Project: St Paul's Church, Hadley Wood, EN4 0EN

Drawing: Arboricultural Impact Assessment

Drawing No: Arbtech AIA 01

DRAWING TITLE
Site Location and Block Plan

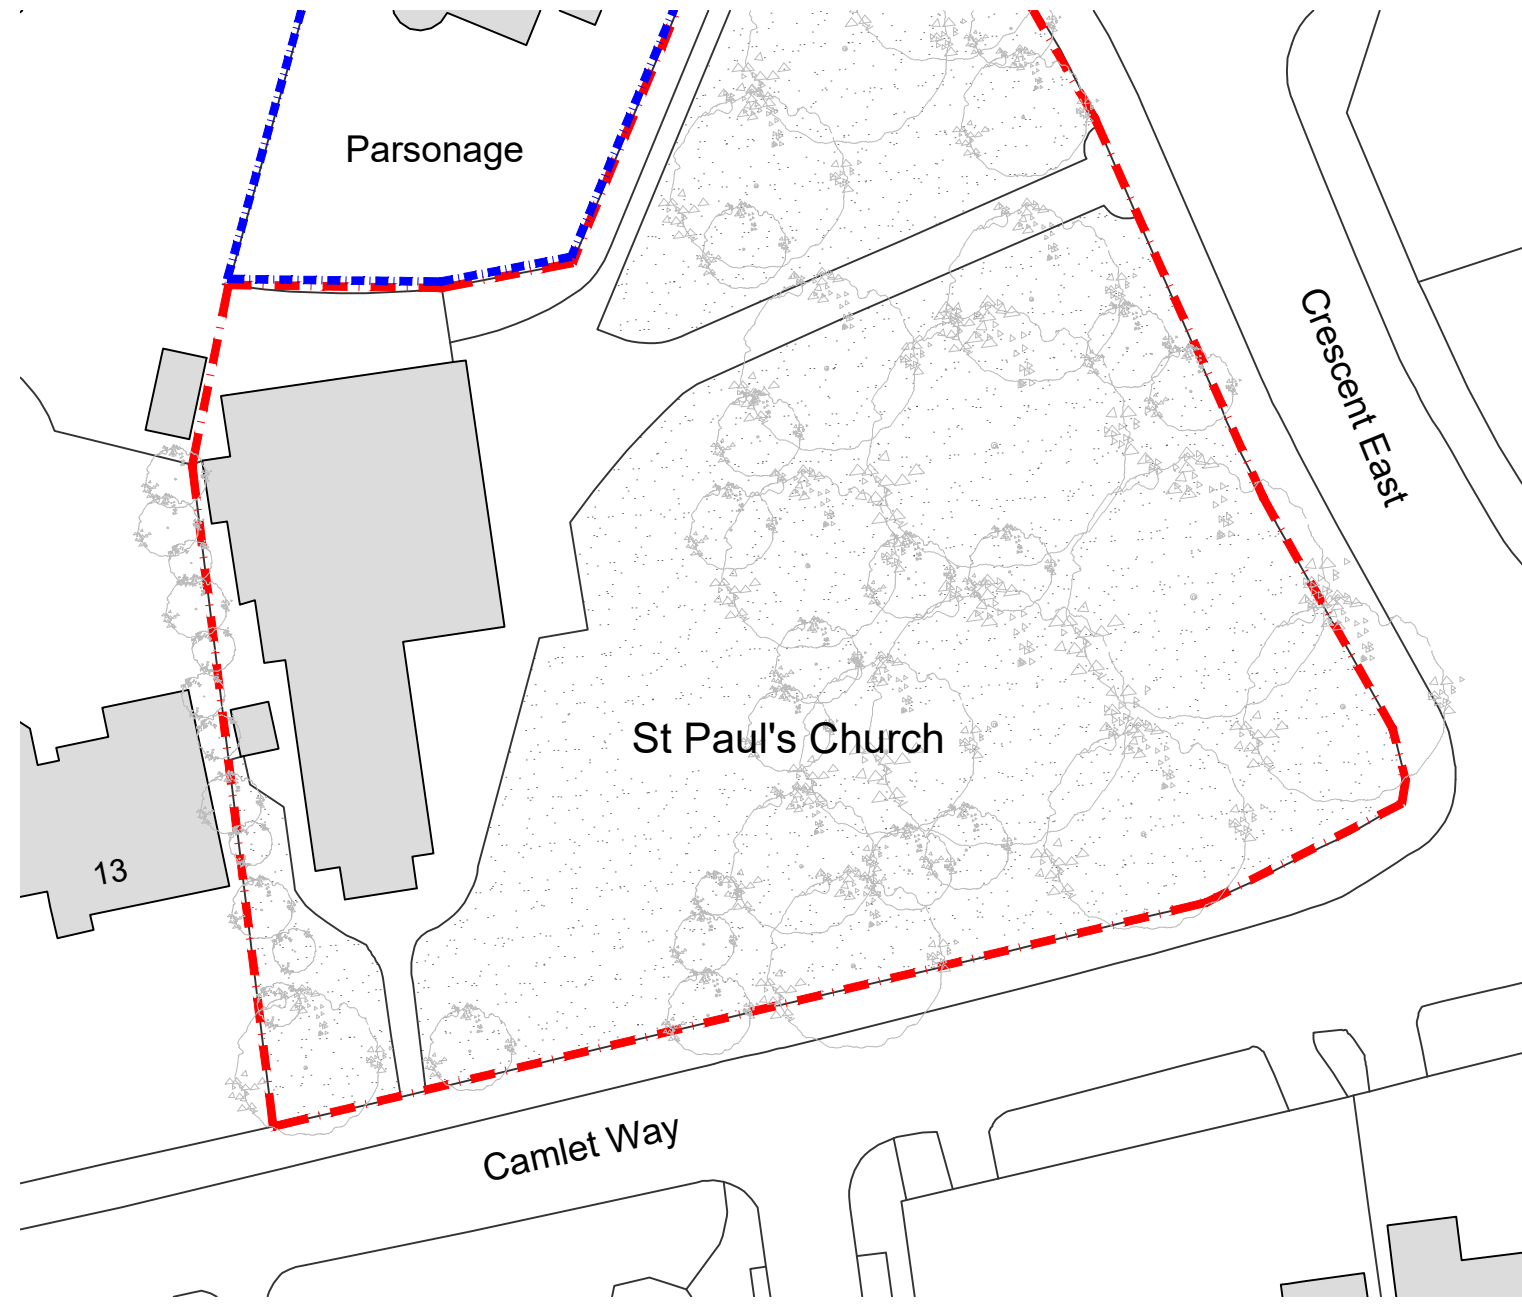
Issue: Proposed hard surface situated within the RPA of trees T01, T02 & T03.
Solution: A cellular confinement system or other approved no-dig engineering system should be used to achieve hard surface treatments in proximity to trees in conjunction with arboricultural advice and site investigations.

Issue: Proposed gatepost replacement situated within the RPAs of retained trees T03 & T04.
Solution: Excavations of posts of the proposed boundary fences within RPAs are to be undertaken manually under arboricultural supervision; posts may need to be relocated if roots important to the stability of the tree will be affected.
OR
Gates are to be hung from the existing brick pillars and no excavations will be required.
